Environmental Health Division
1675 W. Garden of the Gods Road
Suite 2044
Colorado Springs, CO 80907
(719) 578-3199 *phone*
(719) 578-3188 *fax*
www.elpasocountyhealth.org

Muddy Little Cowboy Ranch Agritainment, AL-19-028

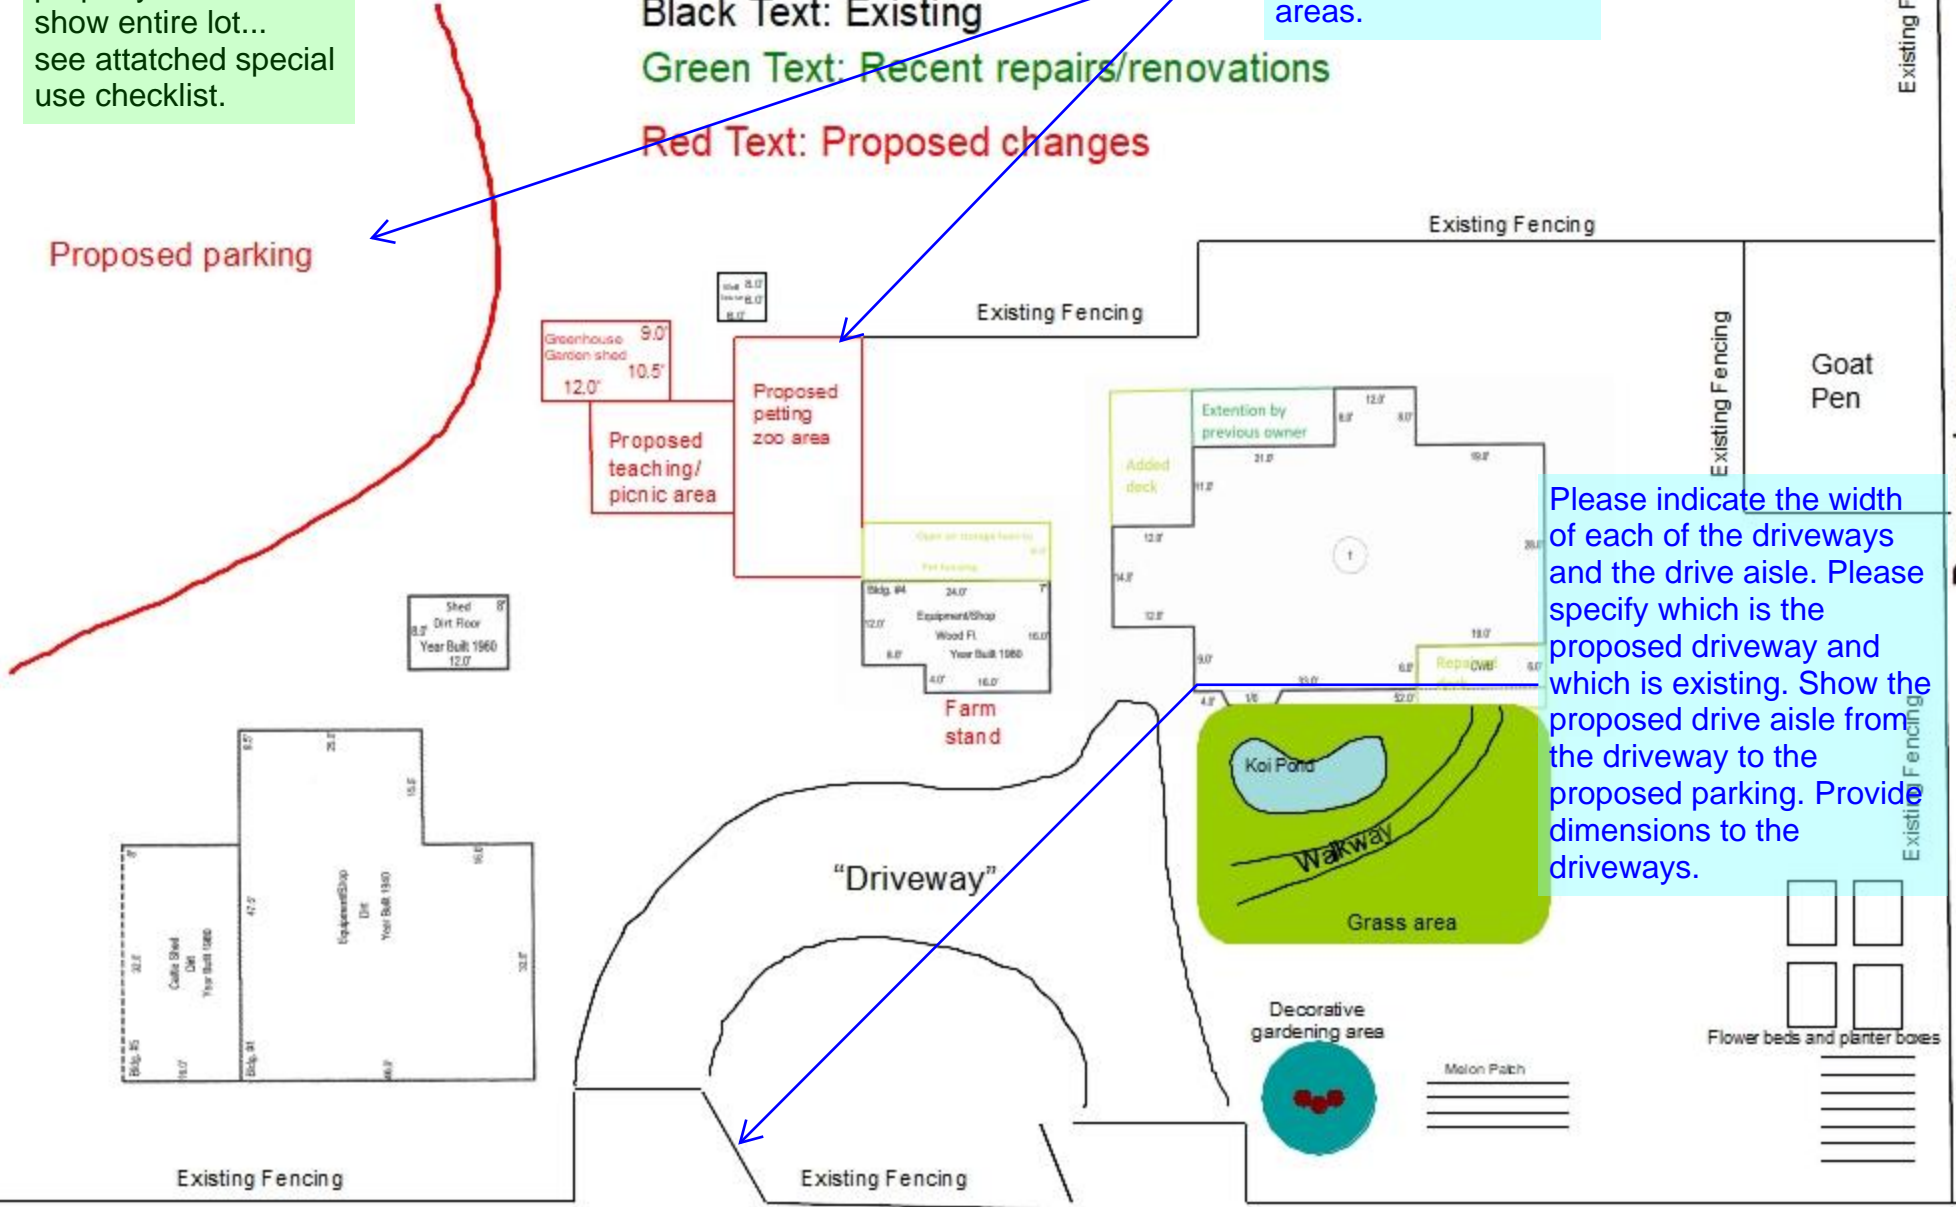
- **A record of an approved, permitted on-site wastewater treatment system (OWTS) for this property indicates the OWTS was installed and approved in 2018. The OWTS component locations are on file at El Paso County Public Health under Tax Schedule Number (TSN) 370000045.**

- **Portable toilets are proposed for use and are approved based on temporary operation during the months of May through October.**
- **Please assure all components of the OWTS are located and protected from vehicular traffic, livestock and other means of compaction. A secondary site on the property must be preserved for the possibility of a repair, addition, or replacement of the existing soil treatment area. Fencing is preferred but other soil treatment area identification methods accomplishing the same goal are approved.**
